Our Ref: F2025/00890
(Contact Officer: Joseph Edmonds, ph: 9093 6955)

Reference number	SSD-81426710
Subject Land	138 Maroubra Road, Maroubra
Proposal:	Construction of a nine-storey mixed-use development comprising a residential flat building and ground floor retail premise, including: - 27 x 1-bed apartments, including 7 affordable dwellings - 14 x 2-bed apartments, including 6 affordable dwellings - 23 x 3-bed apartments - Communal open space at rooftop level and on level two Replacement of an existing single level of basement to provide basement car parking, plus additional parking provided above ground on the first storey. The application is seeking an infill affordable housing bonus under the SEPP Housing 2021, noting that 13 affordable housing units are proposed within the scheme.

I refer to your request for Council's review of the Mixed-use development with in-fill affordable housing at 138 Maroubra Road, Maroubra. The following comments are provided for your consideration.

1 POTENTIAL DEVELOPMENT - GROUND FLOOR RETAIL
DA2.109 1 : 450

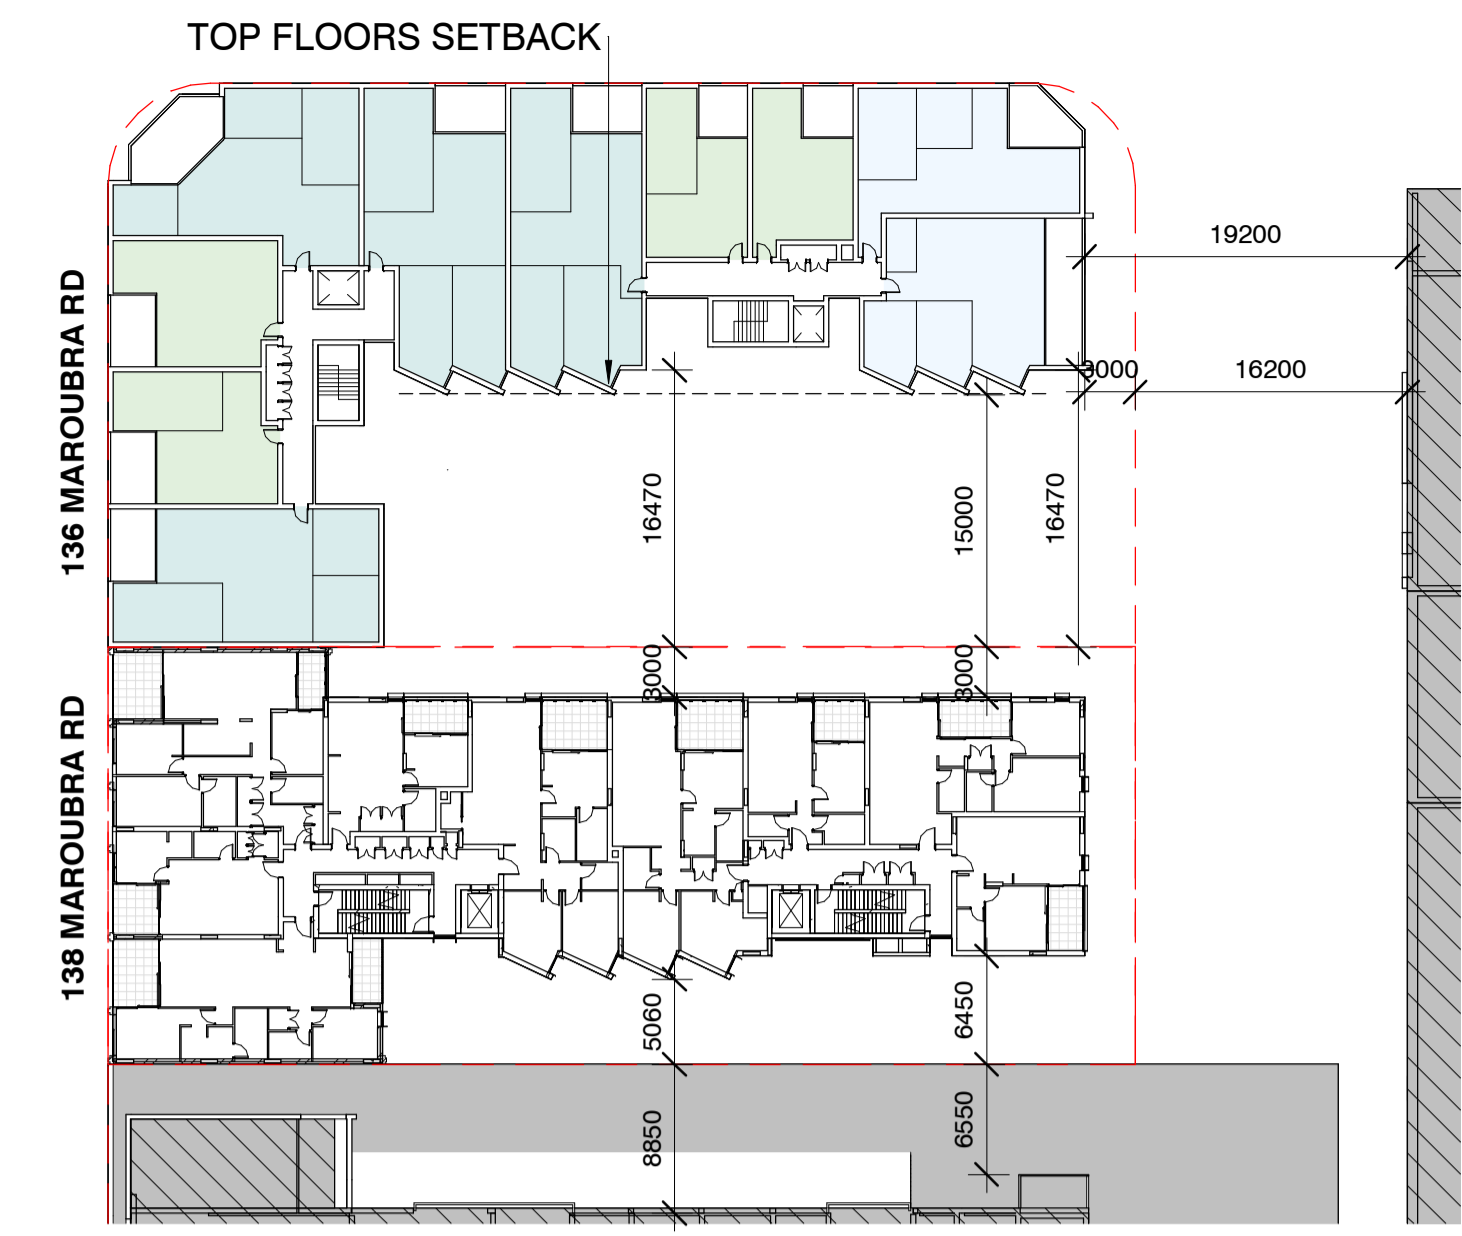
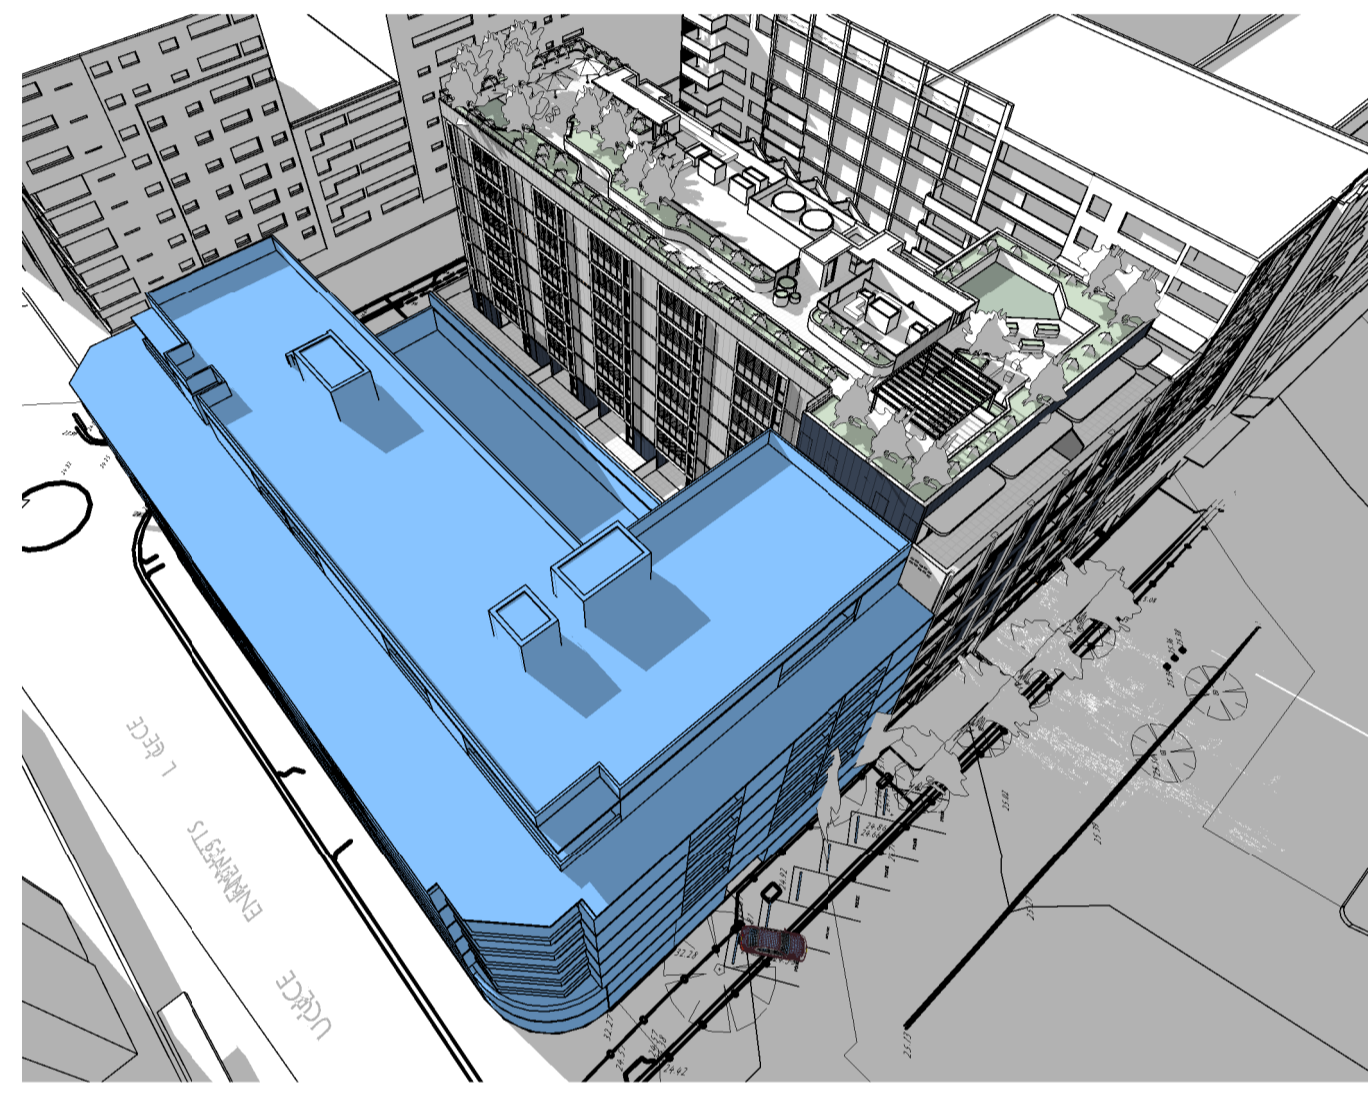
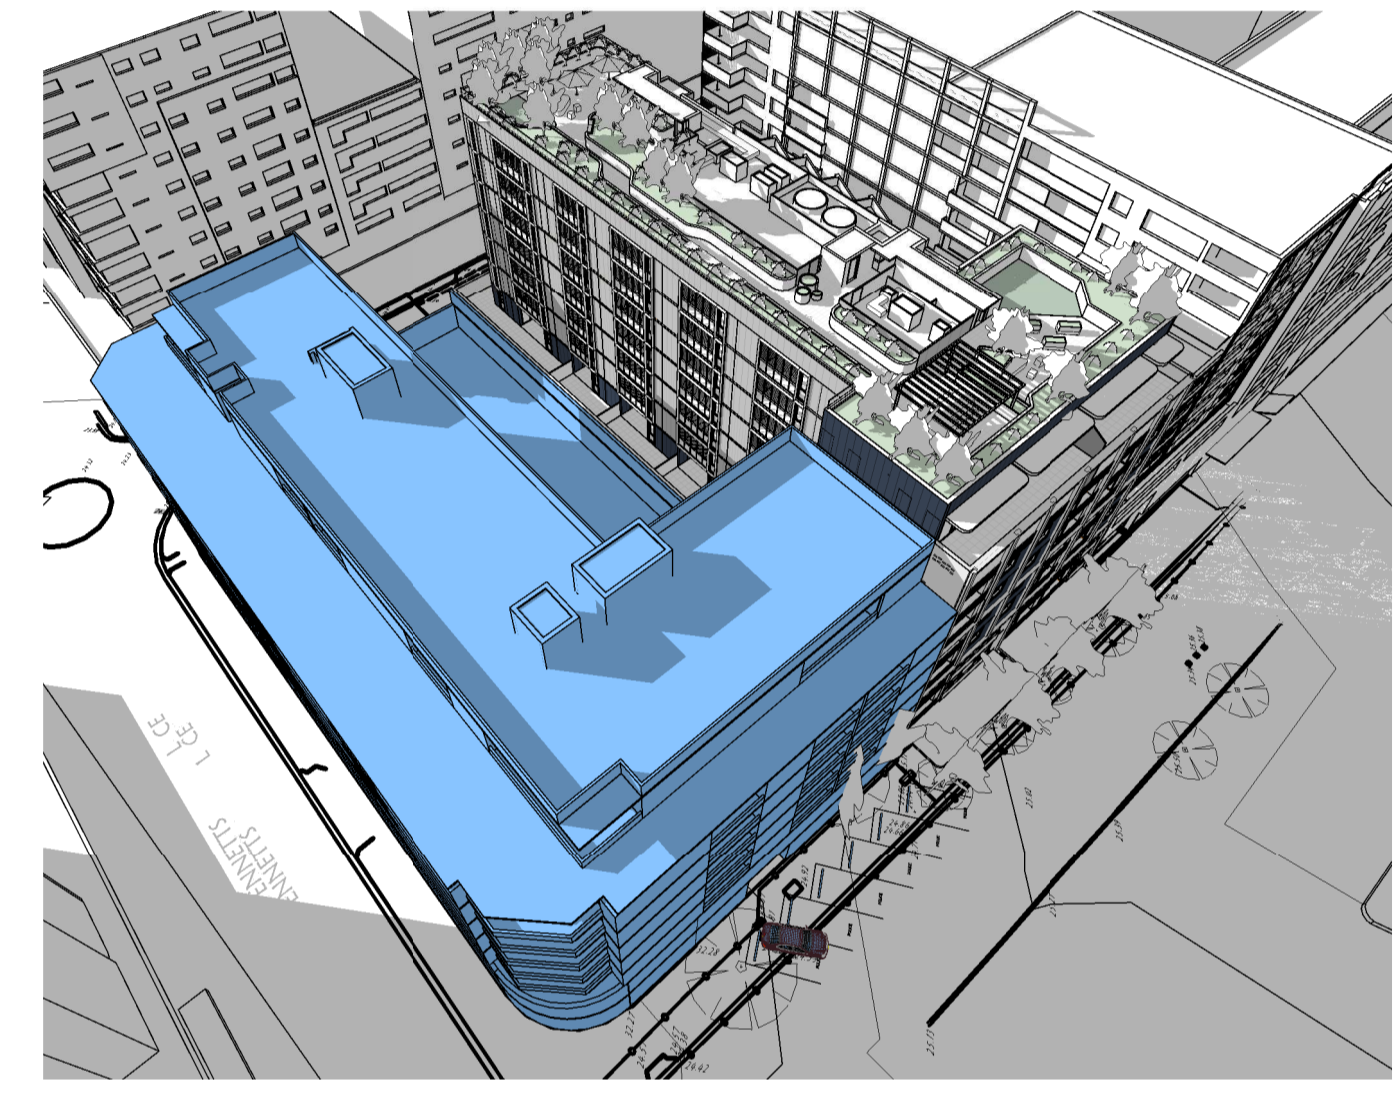
These separations and setbacks are not supported. Concern is raised for the proposed western side setback. It is not considered reasonable for the applicant to assume the redevelopment of the neighbouring property, without any formal block plan. The share of setback distances are not equitable, noting that the development site provides 3m, whereas the adjoining site is being expected to provide a minimum of 15m.

This has not been achieved as the proposal has not adequately considered the future development of 138 Maroubra Road. The applicant has designed a potential development at 138 Maroubra Road, but this does not align with the RDCP or a realistic future development at 138 Maroubra Road.

DRAWN BY	SCALE	SHEET SIZE	PRINT DATE
Author	1:100	A1	18/09/2025
DESCRIPTION			5:09:04 PM
GROUND FLOOR PLAN			
PROJECT No	DRAWING No	REVISION	
21_435	DA1.104	V

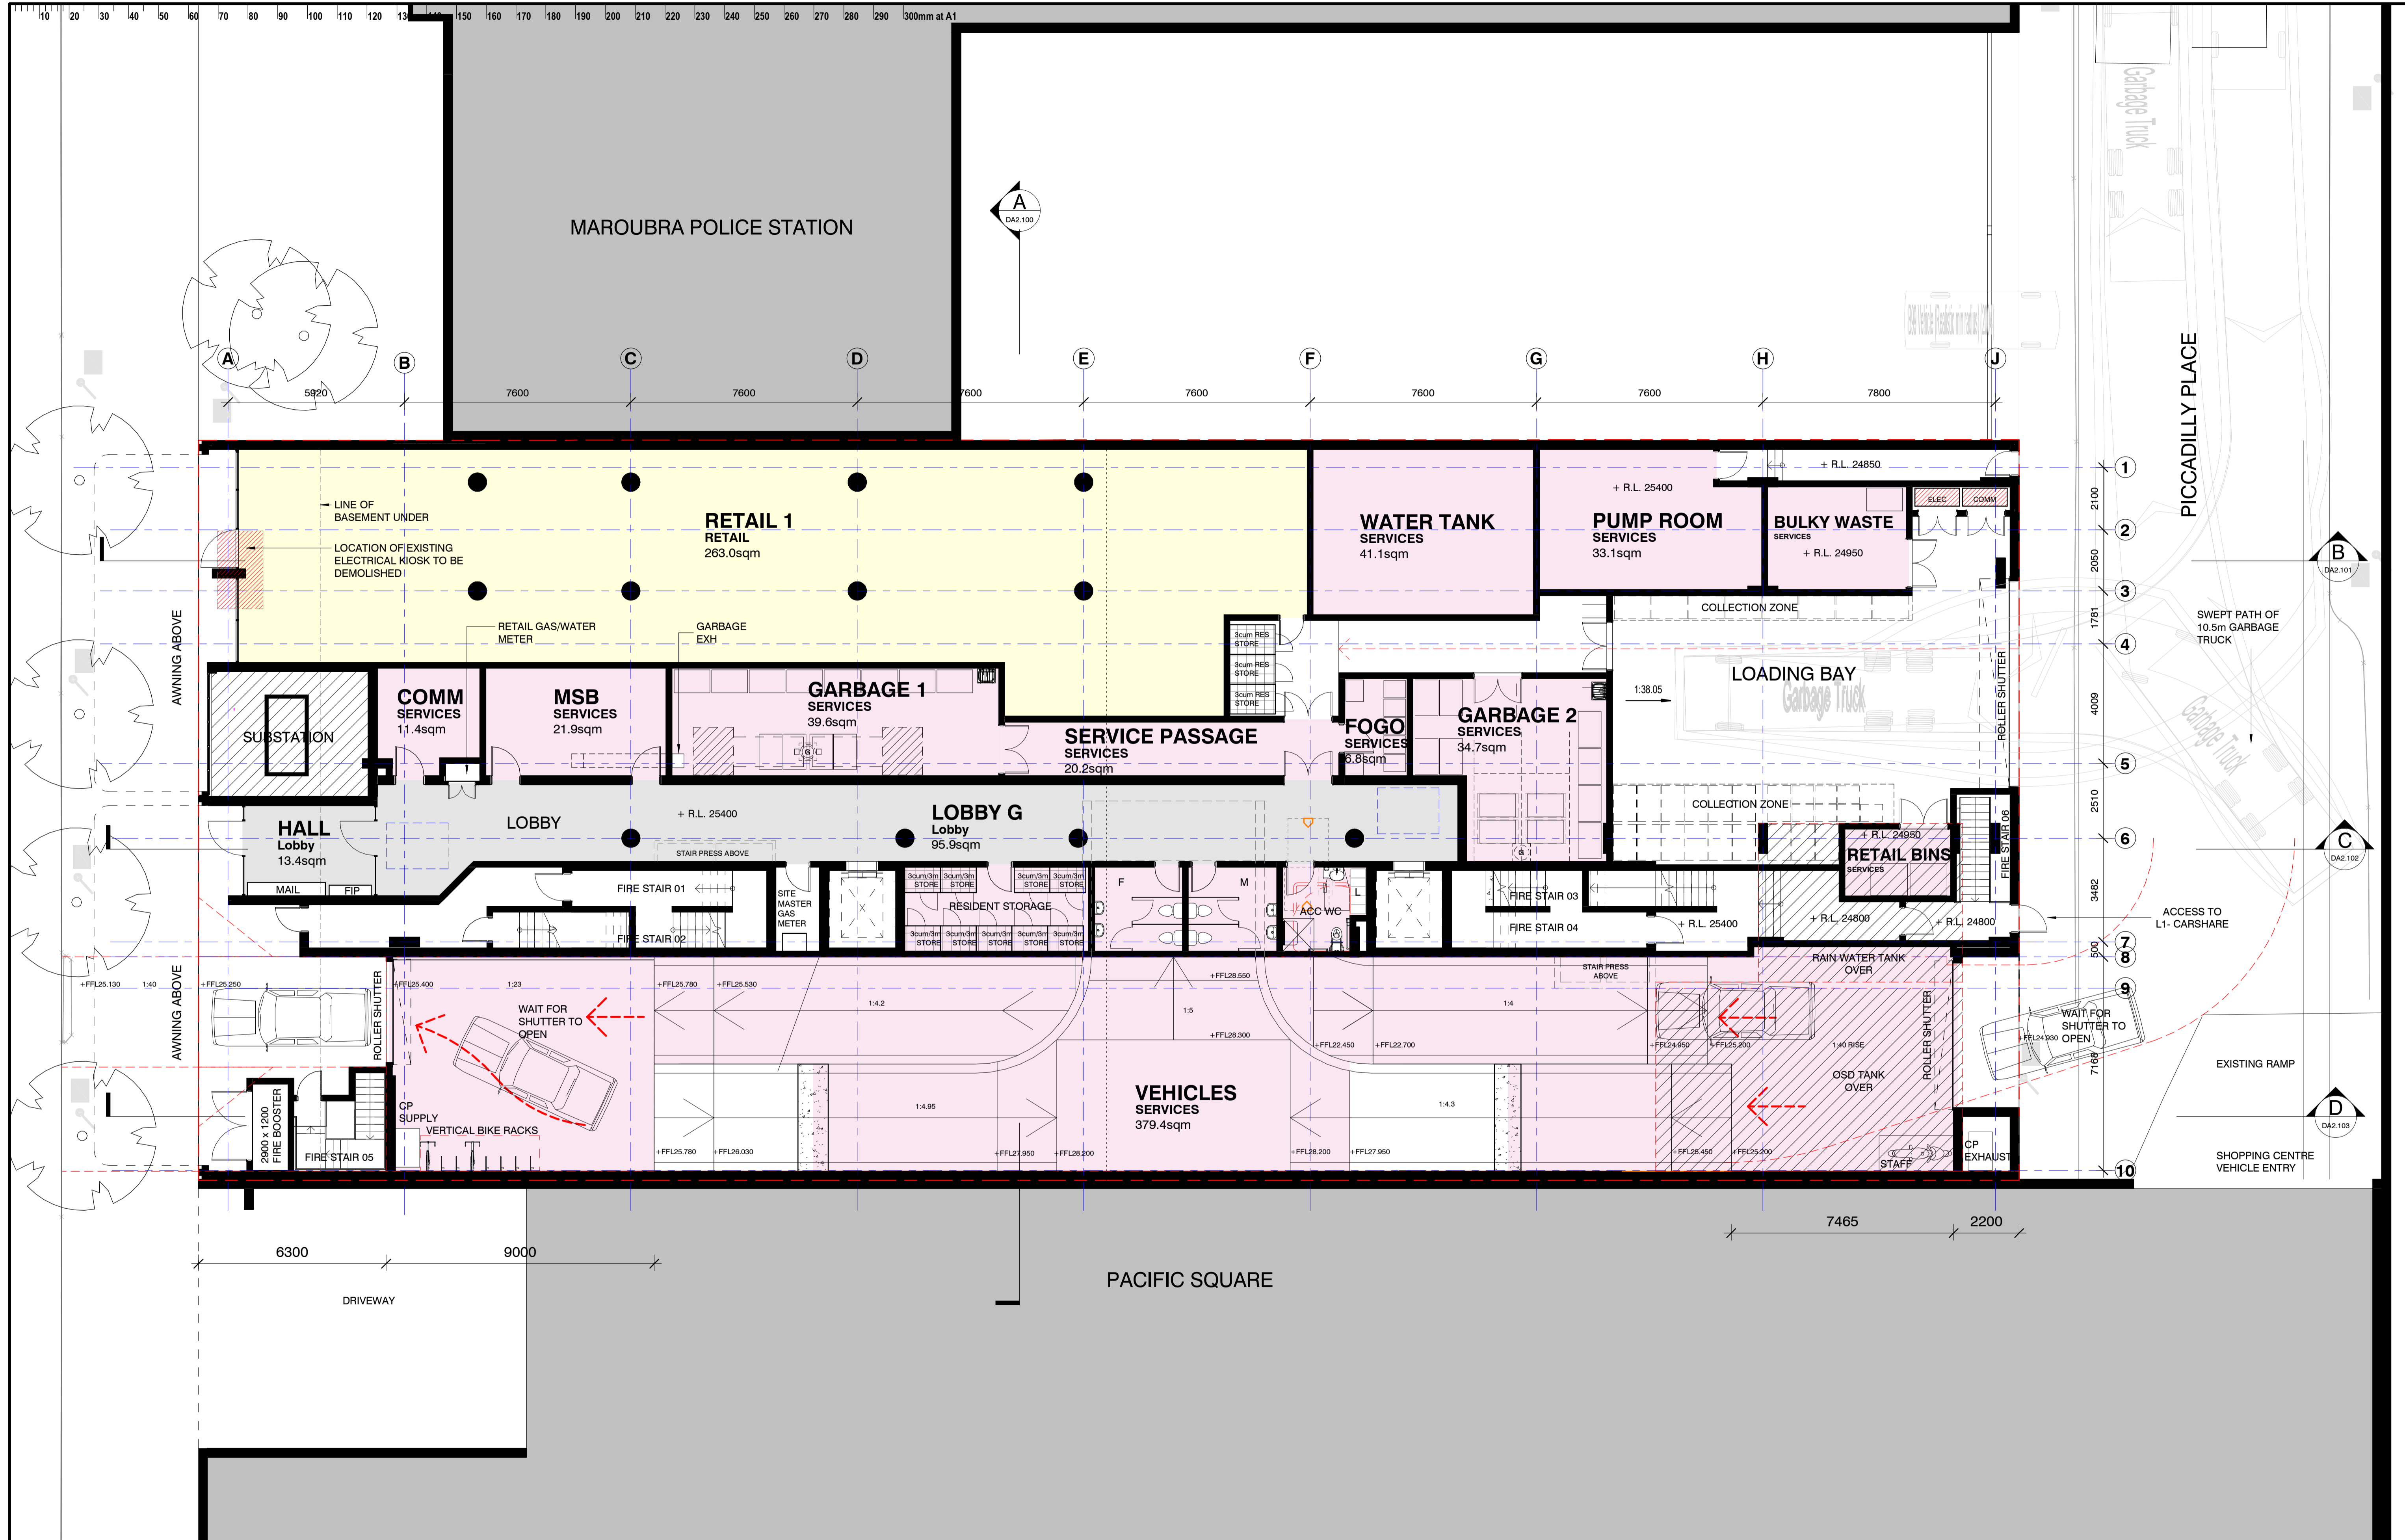
As discussed in the parking section of this advice, the proposal has not provided the required retail and commercial uses. The ground floor configuration does not foster retail activation, with shops and commercial uses. Instead, it is used for the building services and storage or car access. No justification has been provided for the removal of the previous basement levels, and the reasoning for this change is unclear in the documentation.

There is only 1 retail space provided, which is 263m². The other 1220m² of the ground plane is taken up by services, storage or access and is not a supported outcome. As per the Maroubra Junction DCP, the ground and first floors should accommodate further retail and commercial uses.

The proposal is not strengthening the role of the commercial centre because it is not providing suitable retail or commercial spaces. The ground floor should not consist of services, storage and access, this is a poor design outcome.

A vehicular exit onto Maroubra Road is not appropriate outcome – noting the previous comments in relation to the RMS.
